From: [REDACTED]
Sent: 02 June 2020 16:59
To: Anita Gardner <Anita.Gardner@arun.gov.uk>
Cc: 'Shivani Bhardwaj' [REDACTED]; 'Andrew Burns' [REDACTED]; Richard Work [REDACTED]
Subject: RE: A/50/20/PL Variation of Condition application - Pound Place

Subject: A/50/20/PL Variation of Condition application - Pound Place

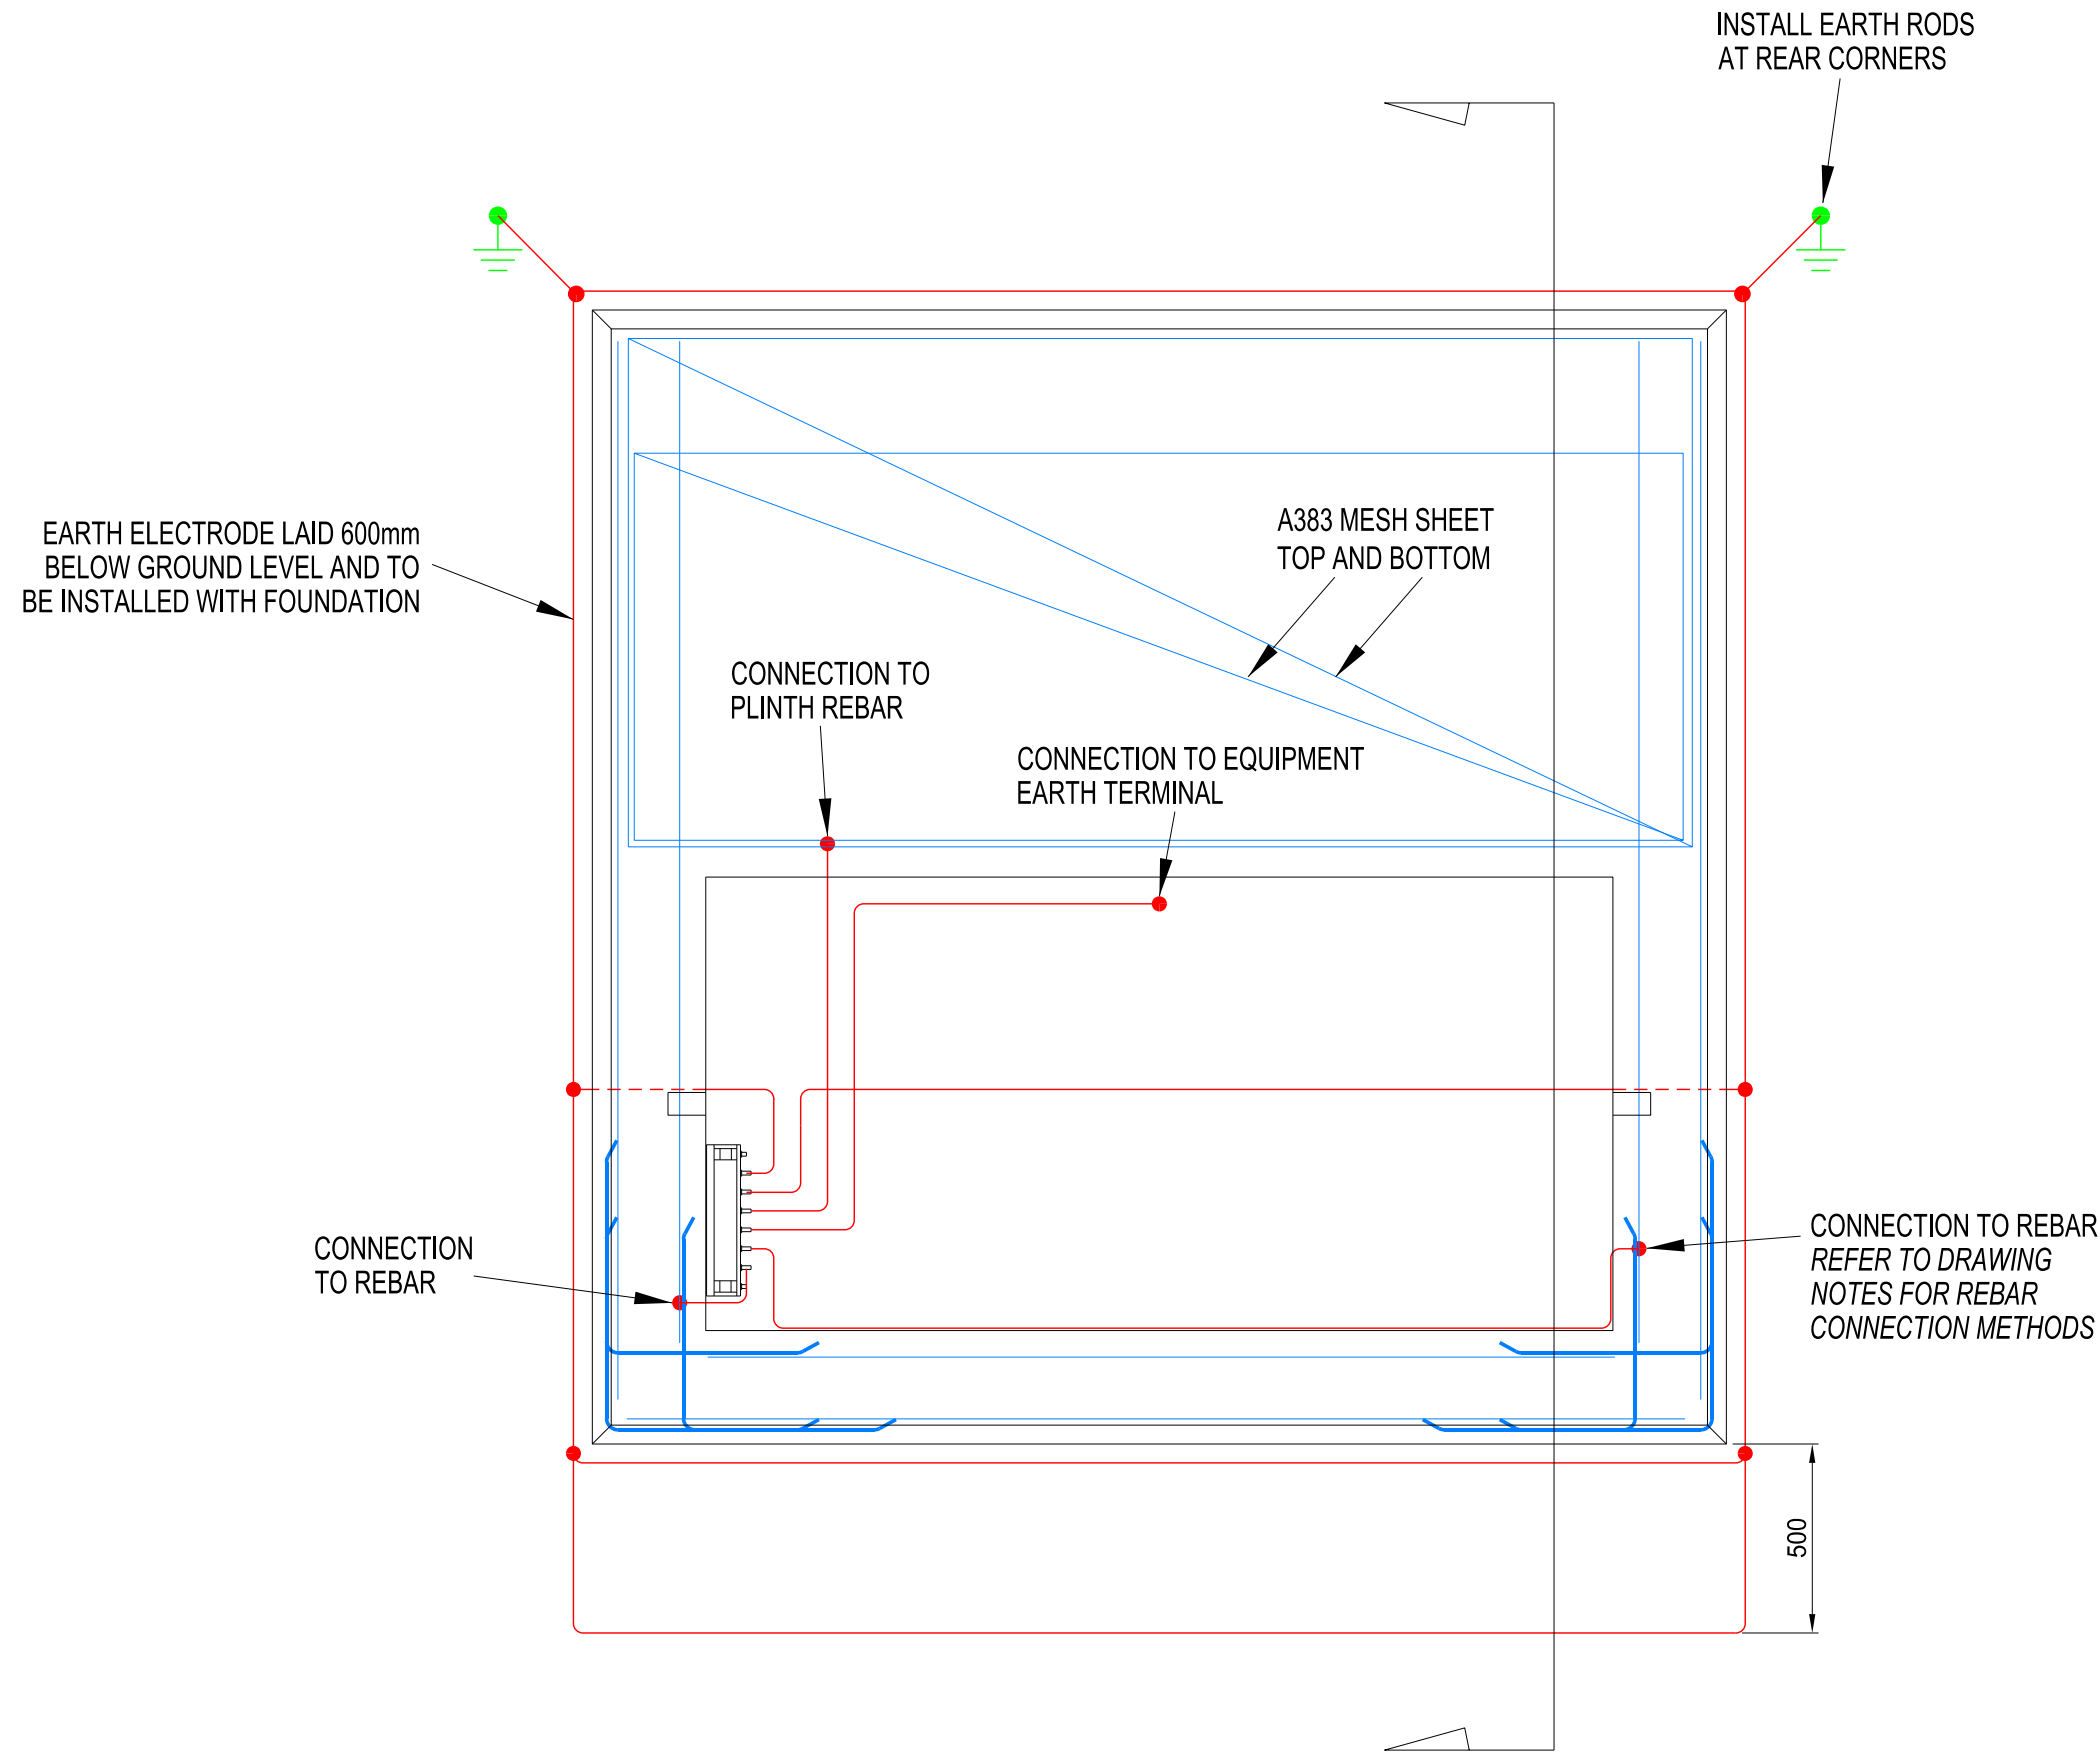
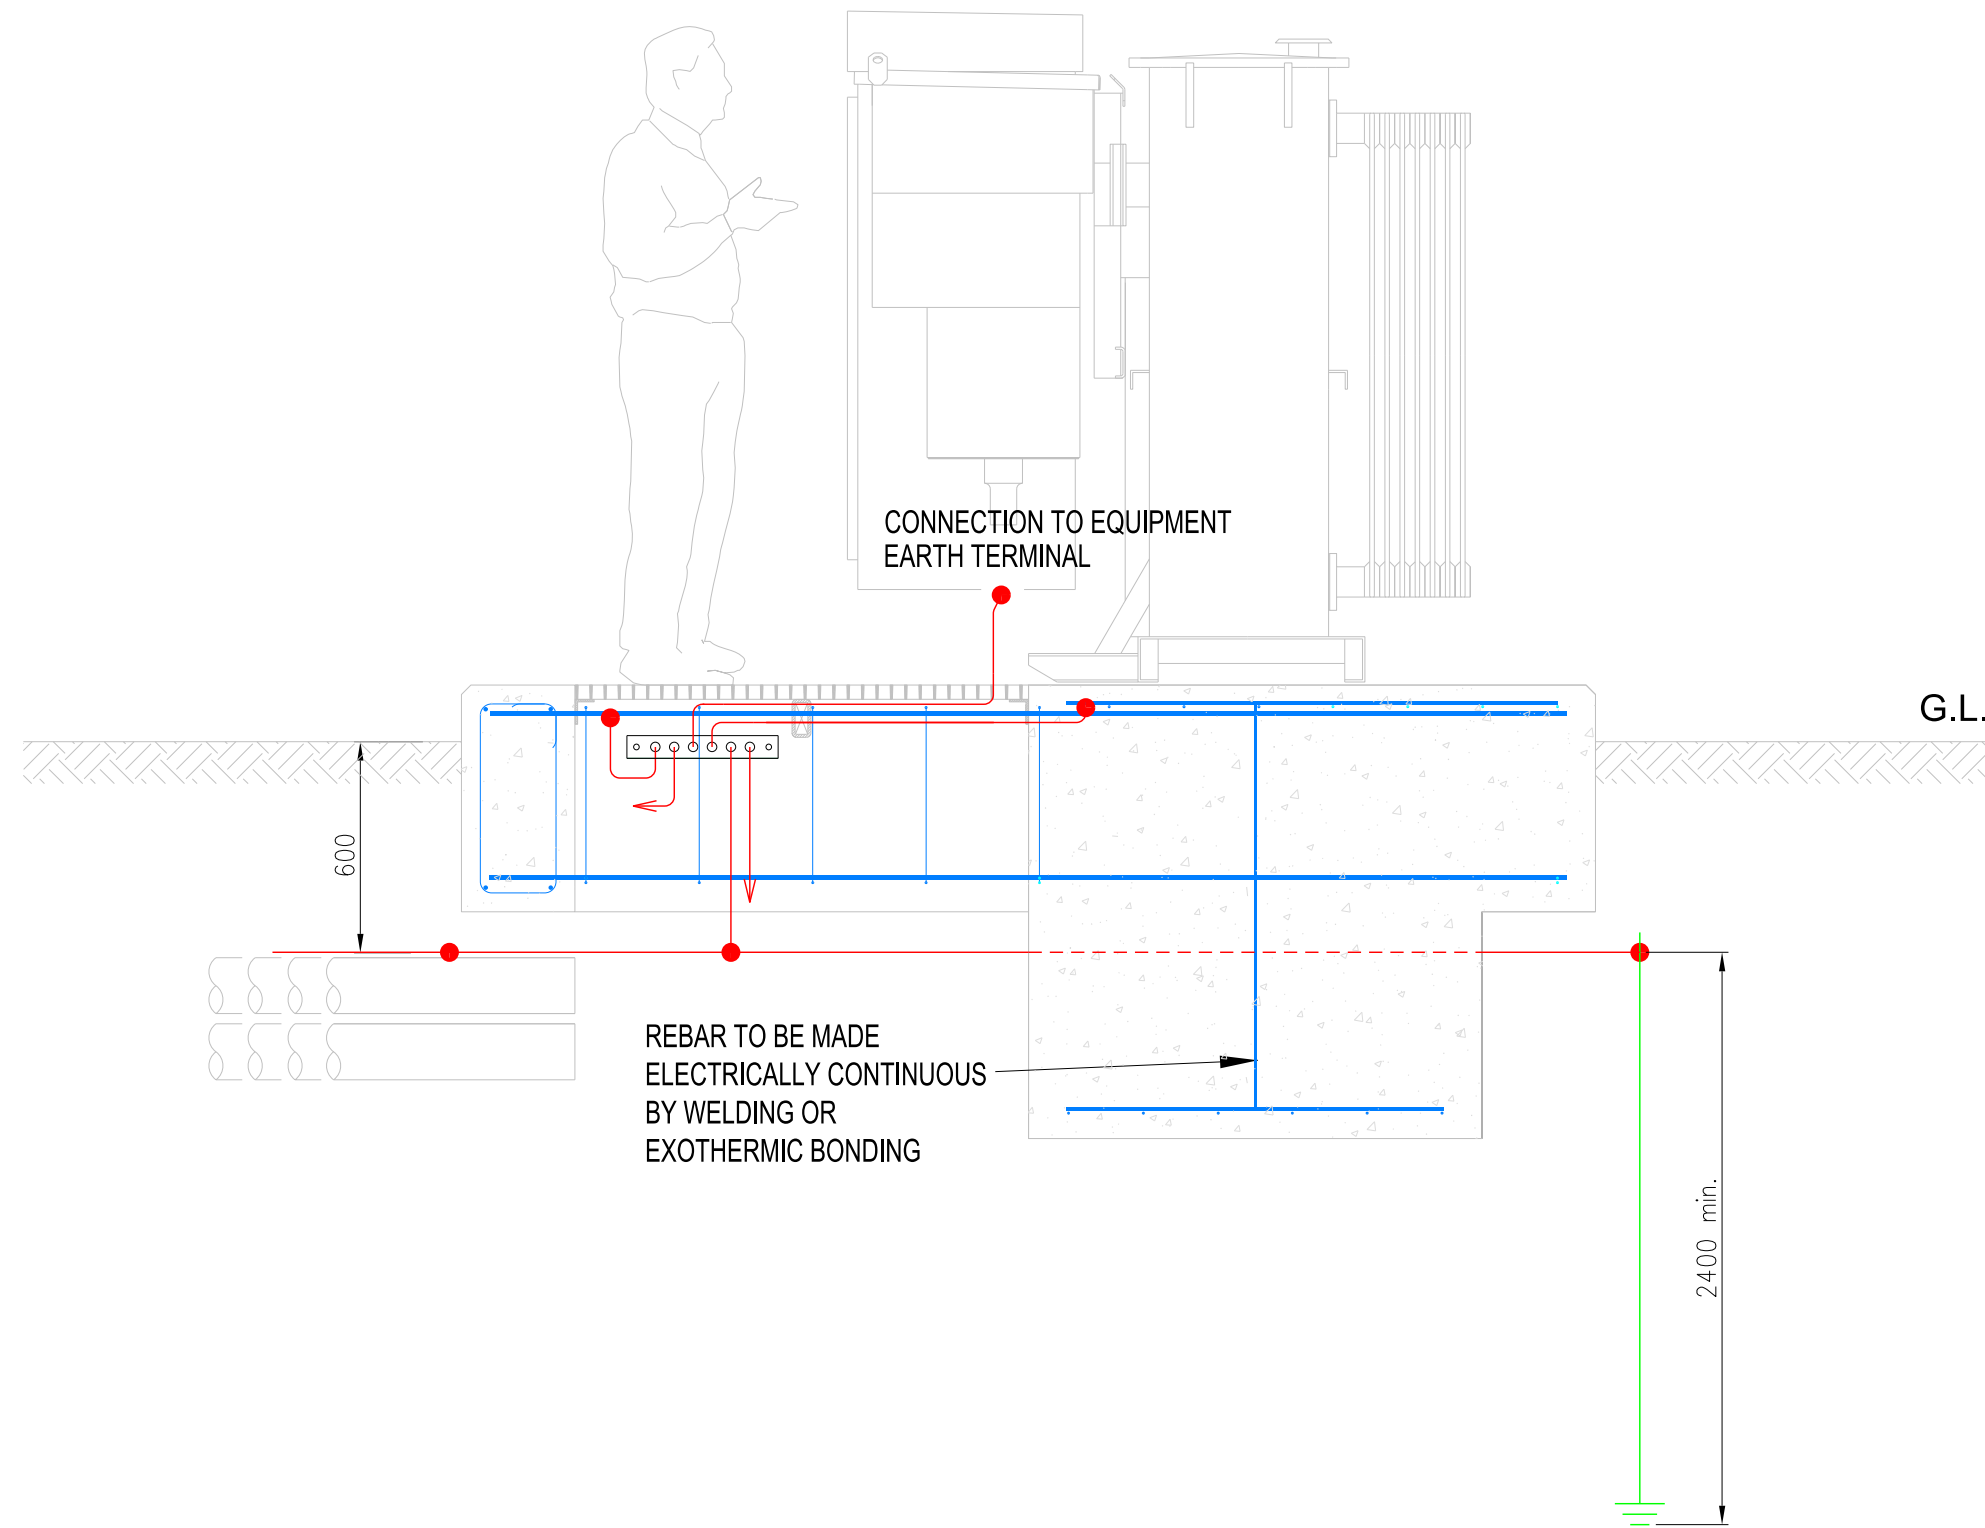
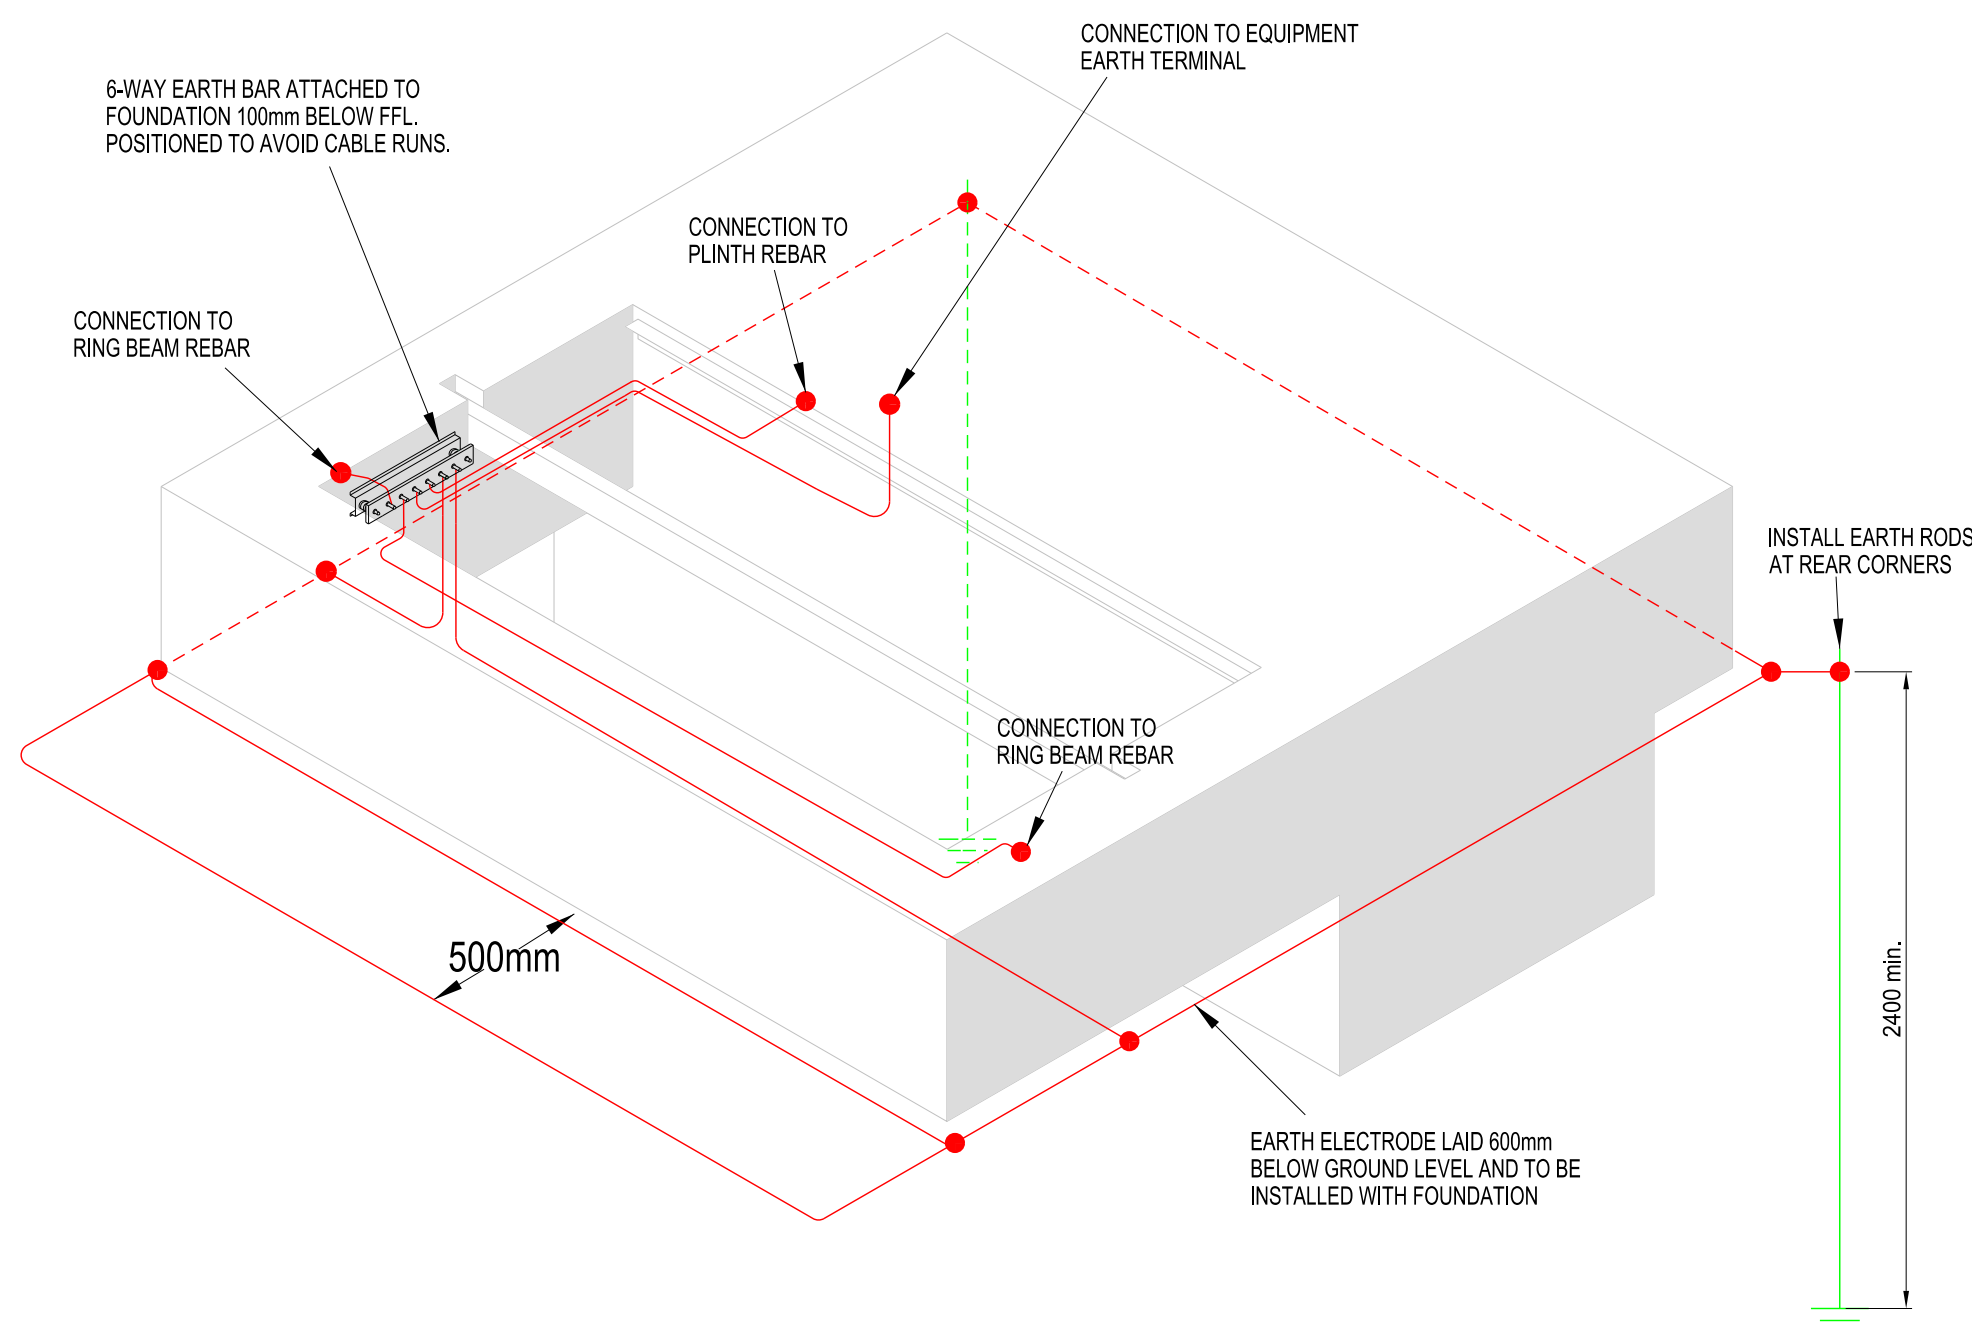
I have started to look at the above application in detail and notice that the drawing entitled Unit and Padmount Substation in a GRP Enclosure EDS-07-3102.01 rev C is incorrect. The Plan view of Site and Equipment refers to back edge of public footpath and the shape of the structure does not seem to accord with the block plan. Can you provide more precise layout details and clearly annotated elevations so that it is clear what elements of the structure are meter housing and generator and what will be visible from no2 adjoining the site and Roundstone Lane. I would also appreciate a street scene detailing the relationship and height of the structure in relation to the boundary with no 2 and proposed planting with a dimensioned distance from the boundary. Is there any opportunity to move the structure further from the site boundary to reduce the impact on the neighbouring property?

- Revised site plan with the correct size and location of the substation including dimensions.
- Correct drawing for the substation.
- Part elevation of the southern boundary showing the substation.
- Revised proposed site boundary drawing.
- Revised general arrangement landscaping plan.

On the substation drawing, the front elevation faces north and the rear elevation faces south.
